**WEST SUSSEX COUNTY COUNCIL
INFRASTRUCTURE CONSULTATION**

SUBJECT: Stables/ Coach House adjacent to 4 Park Place, Arundel ab/24/10/l

PROJECT		Alterations to Coach House at 4 Park Place Arundel.	
SUBJECT		Proposed plans and Elevations	
SCALE	1:50	DATE	Feb 2010
DRAWN		CHECKED	
		DRAWING No.	10 / 12 / 02 A

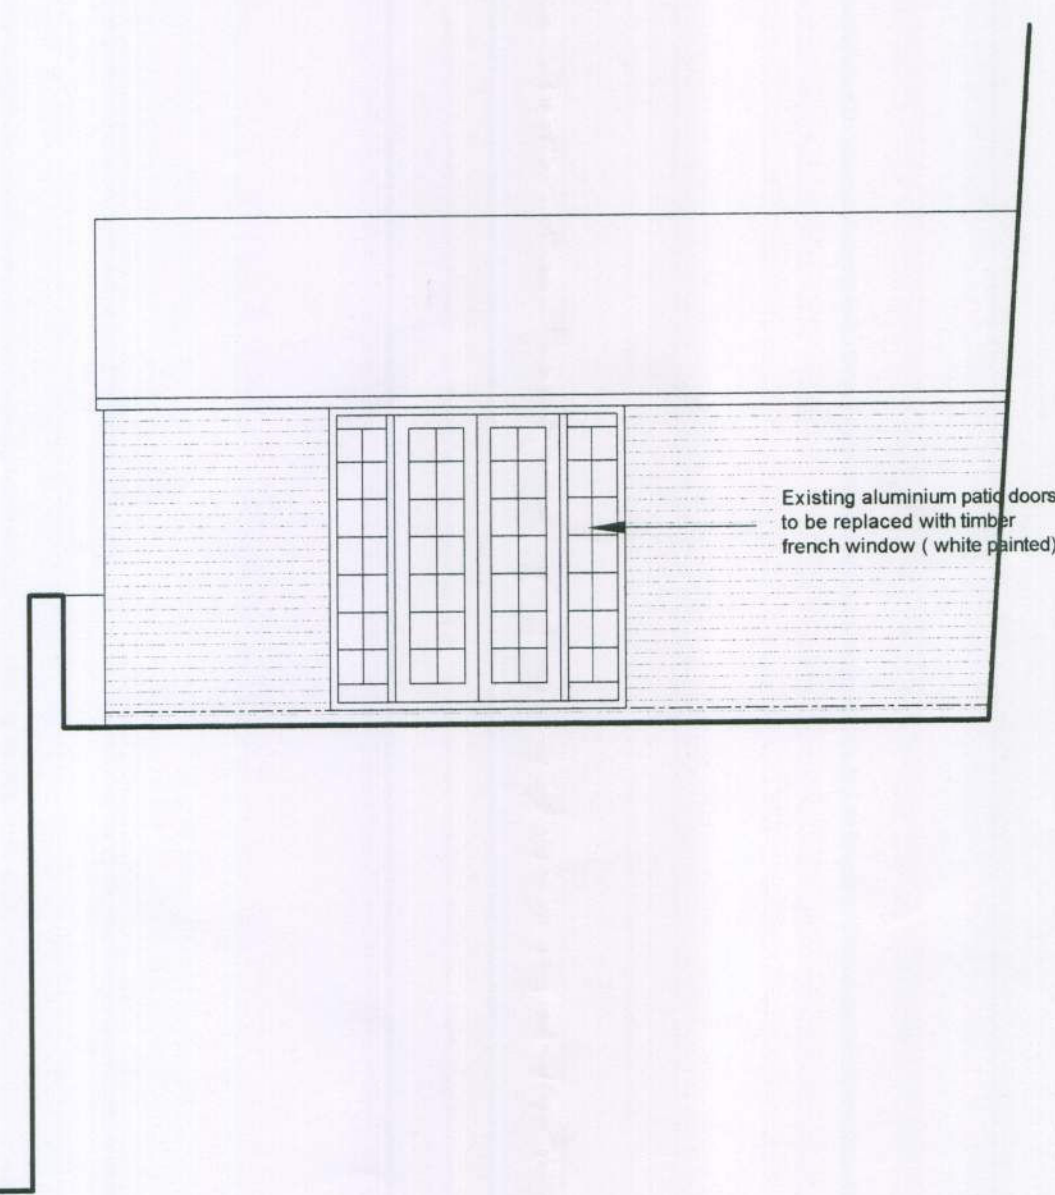
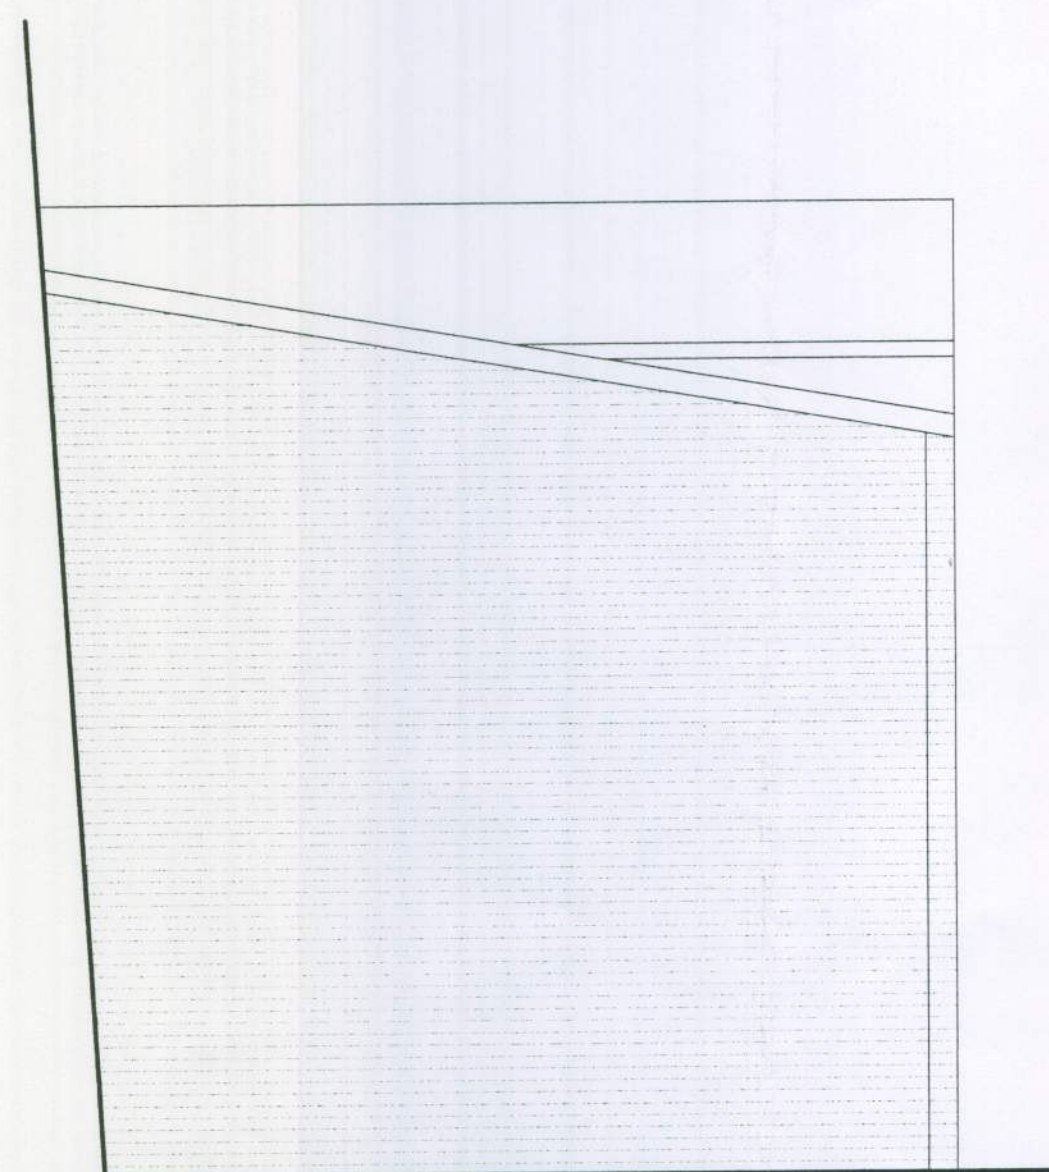
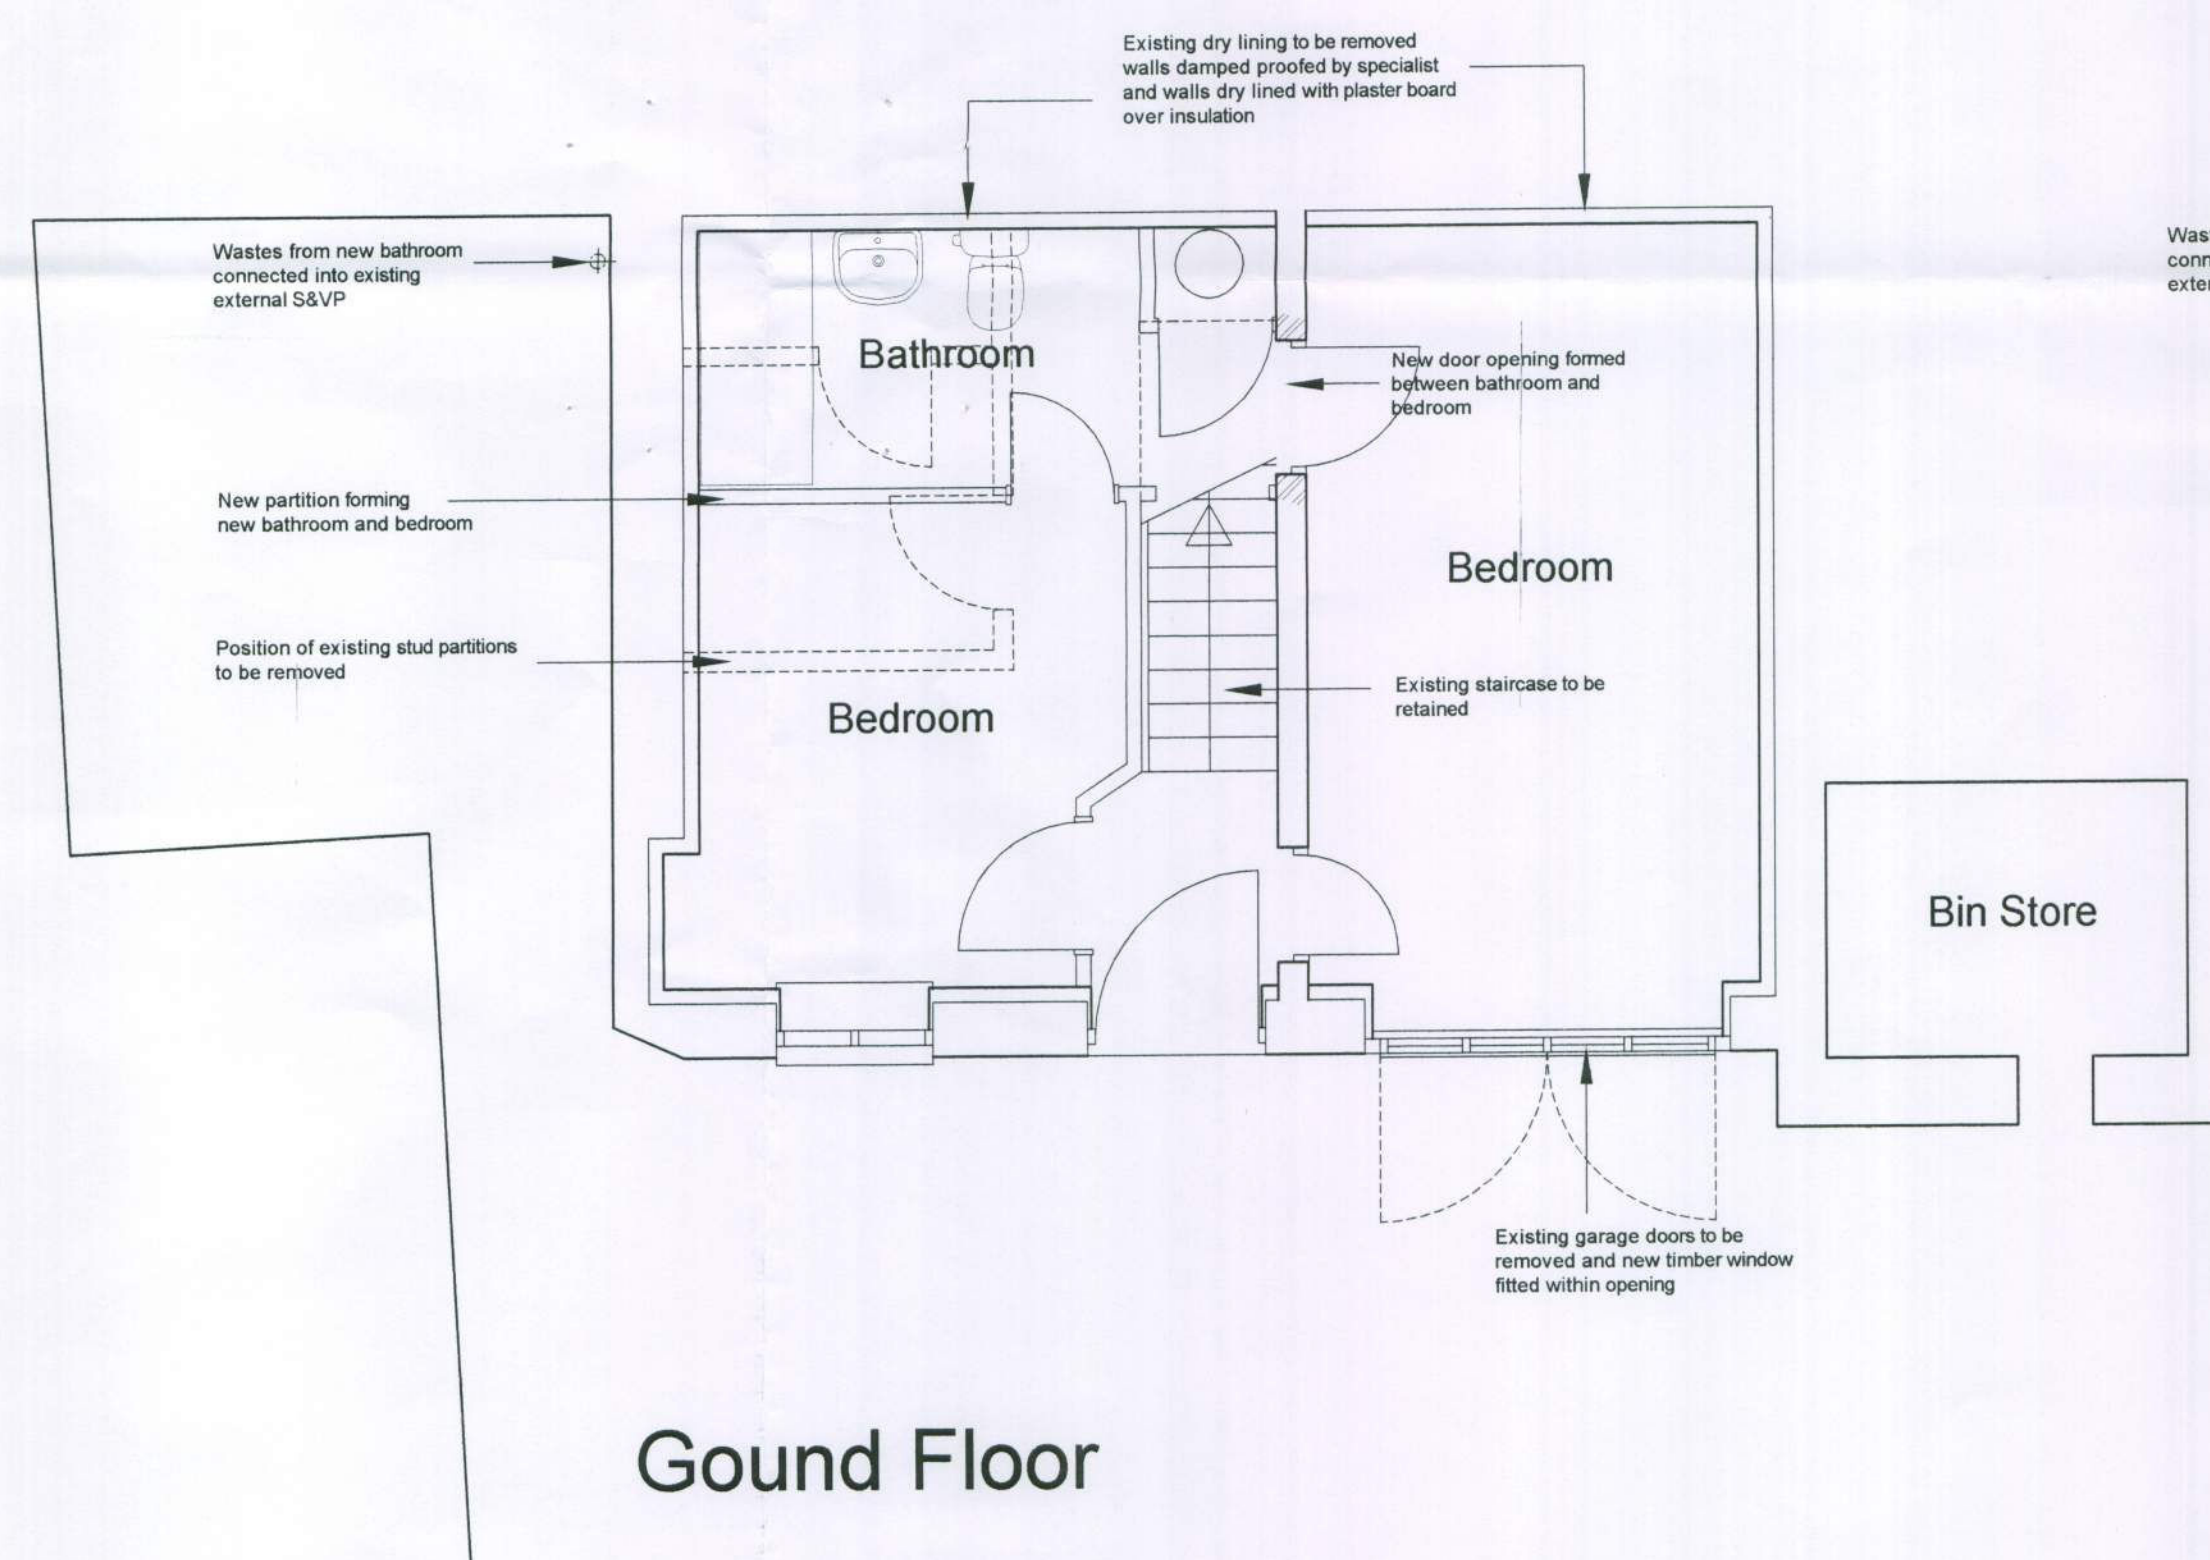
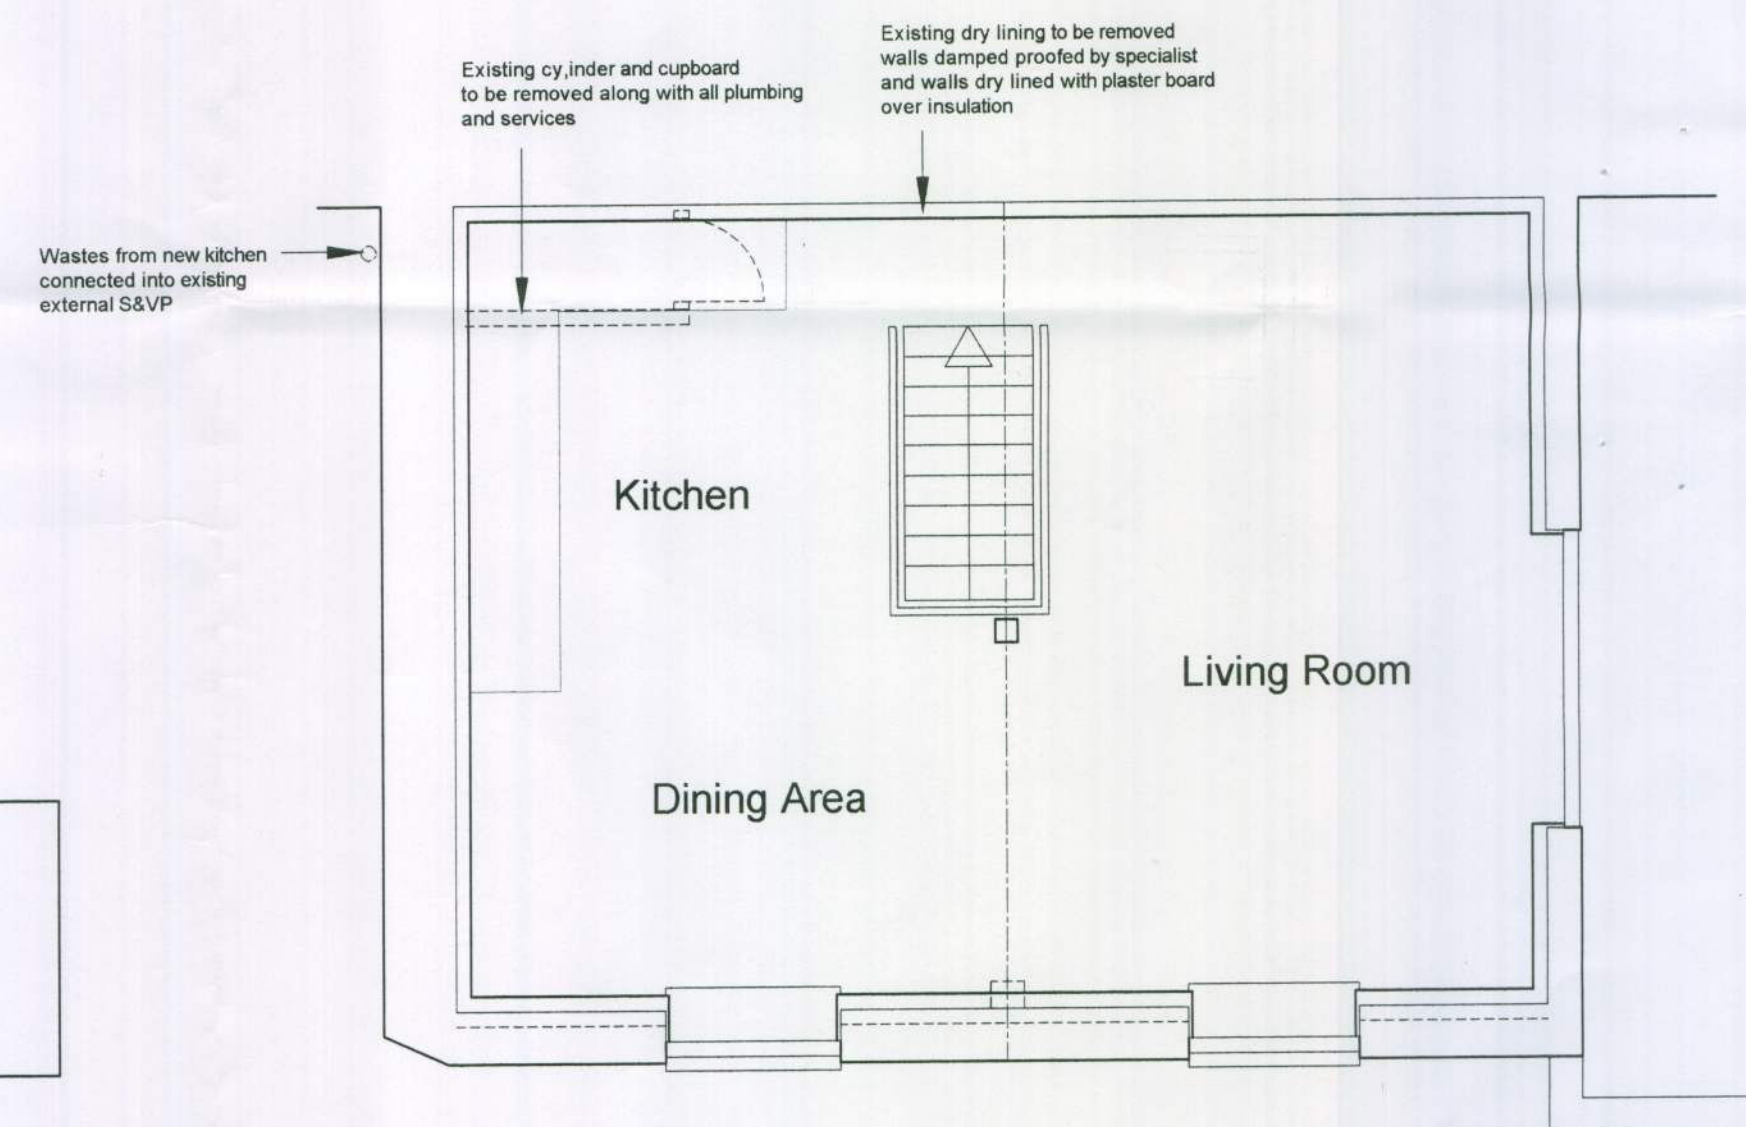
The adaptation of this building to residential use has been sensitively designed. The replacement of the double doors by a large window is not intrusive. The replacement of the aluminium patio door with painted timber french windows is an improvement.
